# **HINCKLEY NATIONAL RAIL FREIGHT INTERCHANGE**

## **Stage 1 Road Safety Audits and Response Report (Local Road Network)**

Document reference: 21.1.1

RESPONSE REPORT

Project - Originator - Zone - Level - Type - Role - Number	Status	Rev
HRF-BWB-HGN-HW07-DR-CH-0100	S2	P03

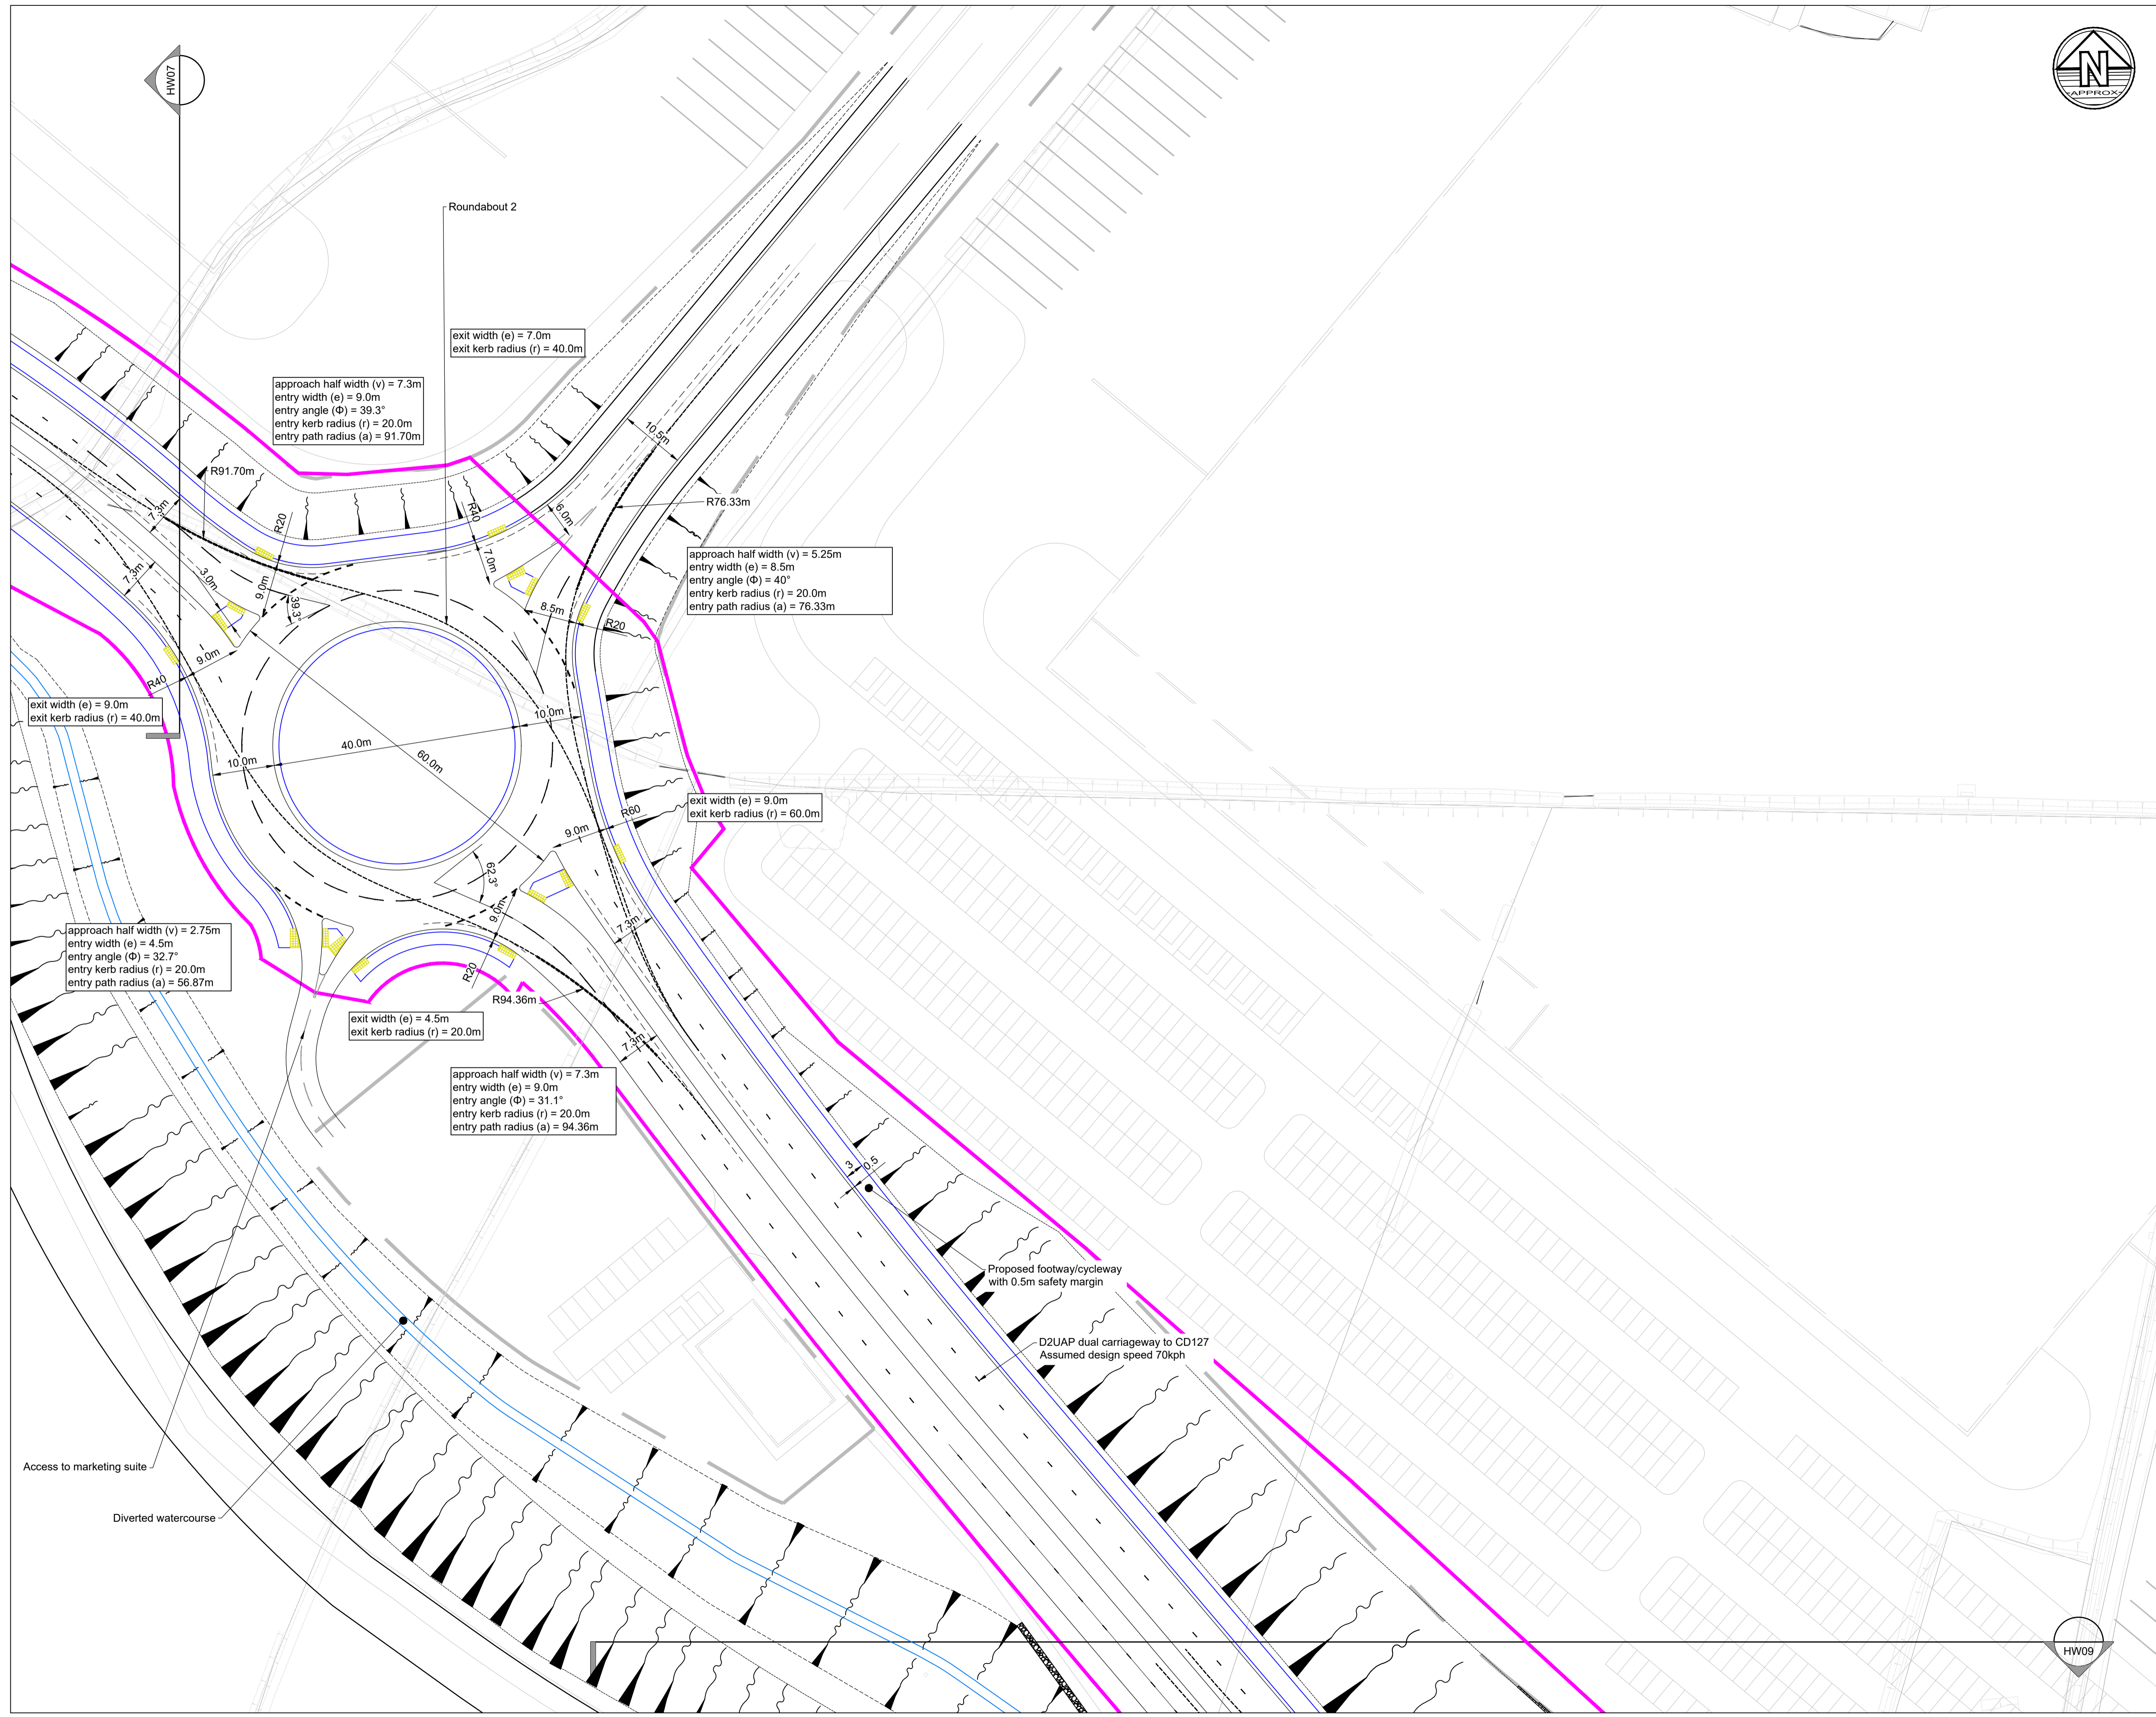
RSA Ref.	RSA Problem and Recommendation	Design organisation response	Overseeing organisation response	Agreed RSA action
3.2	<p>Location: M69 J2 southern circulatory carriageway.</p> <p>Summary: Confusing road markings risk side swipe type collisions.</p> <p>Around the southern carriageway of the circulatory the lane destinations show an “ahead” and a “right turn” arrow. However, approaching the junction and on the approaches before this point, “ahead” and “ahead and right” arrows are shown. This could lead to late lane changes, sudden and unexpected braking and side swipe type collisions due to driver confusion and late decision making as a result of confusing and misleading lane destinations.</p> <p>Recommendation:</p> <p>It is recommended that the markings are amended so that they are consistent with the available movements around the southern half of the circulatory and on the westbound link road exit.</p>	<p>Agree with RSA Recommendation: Yes</p> <p>Road markings on the circulatory will be reviewed during detailed design to ensure consistency.</p>

RSA Ref.	RSA Problem and Recommendation	Design organisation response	Overseeing organisation response	Agreed RSA action
3.3	<p>Location: M69 southbound approach to the new signalised junction.</p> <p>Summary: Poor forward visibility of signals risks late braking and junction overshoot type collisions.</p> <p>The southbound off-slip approach to the proposed signals at Junction 2 has a significant vertical and horizontal alignment change on the approach to the current Give-Way line. There is a concern that, given these changes and the existing signing infrastructure, that forward visibility towards the signal heads will not be provided for vehicles.</p> <p>Recommendation:</p> <p>It is recommended that the signals are located and designed, including raised poles and/or gantry signals if needed, so as to provide adequate forward visibility for approaching vehicles. Furthermore, it is recommended that the signing on the approach is amended so as not to pose an obstruction.</p>	<p>Agree with RSA recommendation: Yes</p> <p>Visibility on the existing southbound diverge slip road has been assessed and full stopping sight distance compliant with CD 122 and the design speed of the slip road (70kph) will be made available through the detailed design incorporating site clearance works and relocation of existing signage to ensure that there are no significant obstacles within the visibility envelope.</p>

4.1	<p>Between J2 on the M69 and the first internal roundabout it is proposed to install a Pegasus crossing. The crossing is shown as a single stage crossing for all users, with the roundabout to the north shown as only a two-arm junction at this time. The crossing is approximately 18m in length - as part of the detailed design it should be ensured that the crossing timings and on-crossing detection account for slow moving equestrians, especially as the central splitter island is not of sufficient width for equestrian or cyclists to safely wait..</p>	<p>Noted. Crossing timings will be specified at detailed design with due regard for all potential users of the crossing.</p>
